SUBJECT: Highway 9 Office Park BL-16-00016

County Survey review of Highway Park 9 (BL-16-00017)

Required Changes:

PRELIMINARY BOUNDARY LINE ADJUSTMENT

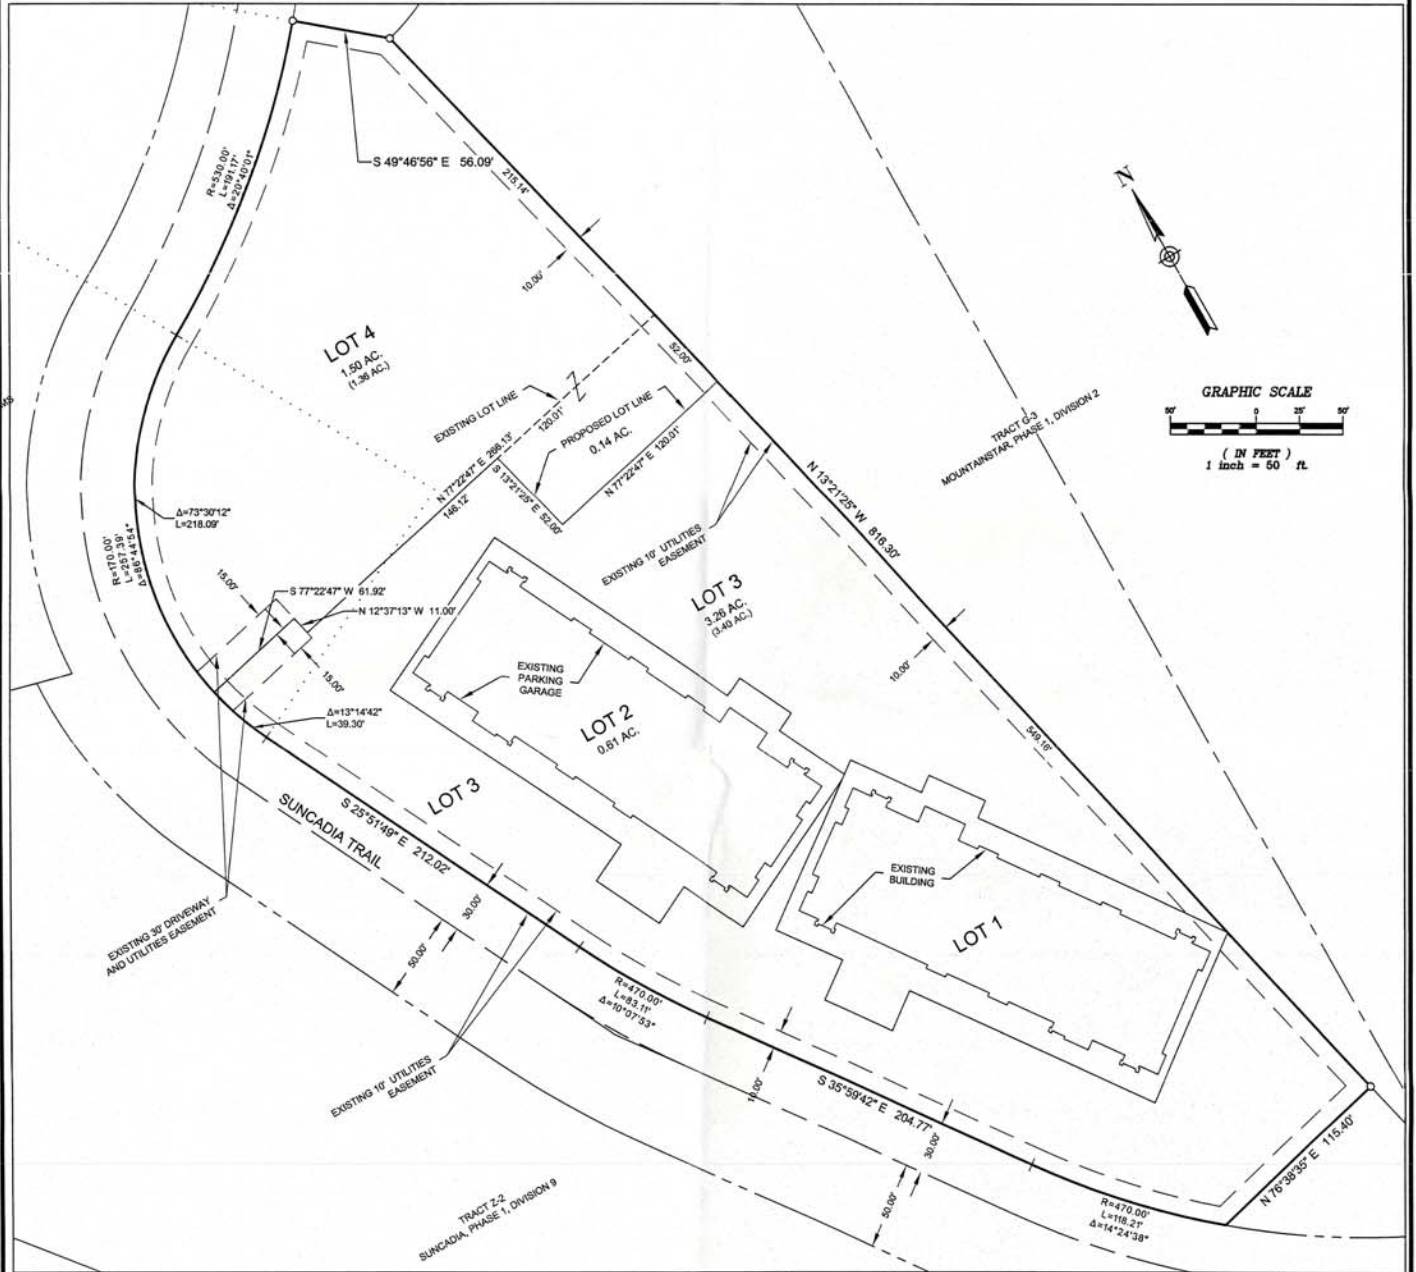
1. The boundaries shown as Lot 1 and Lot 2 are not dimensioned. Additionally, Lot 1 and Lot 2 should be relabeled to reflect the recording number of the document creating them, so it is not construed that they are a part of the Boundary Line Adjustment.

1. (EX: Lot 1 (B:39,P:2))
2. Surveyors Certificate is missing. (RCW:59.09.080),(WAC:332-130-050(1)(a)(iii))
3. Survey Procedures statement missing. (WAC:332-130-050(1)(a)(i))

4. There is no Legend. Legend shall include found and set corners, describing each.
5. There is no Basis of Bearing either shown, or noted. (WAC:332-130-050(1)(b)(iii))

6. At minimum, property corners shall be set to delineate the new division line.
7. Roadways shall include width, underlying ownership, Easement or right of way, and surfacing material. (EX: Suncadia Trail – Private R/W – Paved)

8. Remove “MS” text at west border edge (RCW:58.09.050(4)),(WAC:332-130-050(1)(d)(i))
9. Recording numbers of the 2 existing easements should be added to the easements.

10. Recording numbers to the 2 adjacent tracts should be added.
11. The new division line should be drawn with a heavy solid line similar to the perimeter of the parent parcel.

12. “Recording Certificate” should be changed to “Auditor’s Certificate” (RCW:58.09-080),(WAC:332-130-050(1)(a)(ii))
13. Reference note containing the purpose of the survey together with the application number should be added (KCC:16.10.020(1)) (EX: The purpose of this survey map is to meet the requirements of Kittitas County BLA application 16-00017)

14. The dimensions 215.14 and 52.00 feet are misleading. This could be corrected with crowfeet, or by changing the distances.
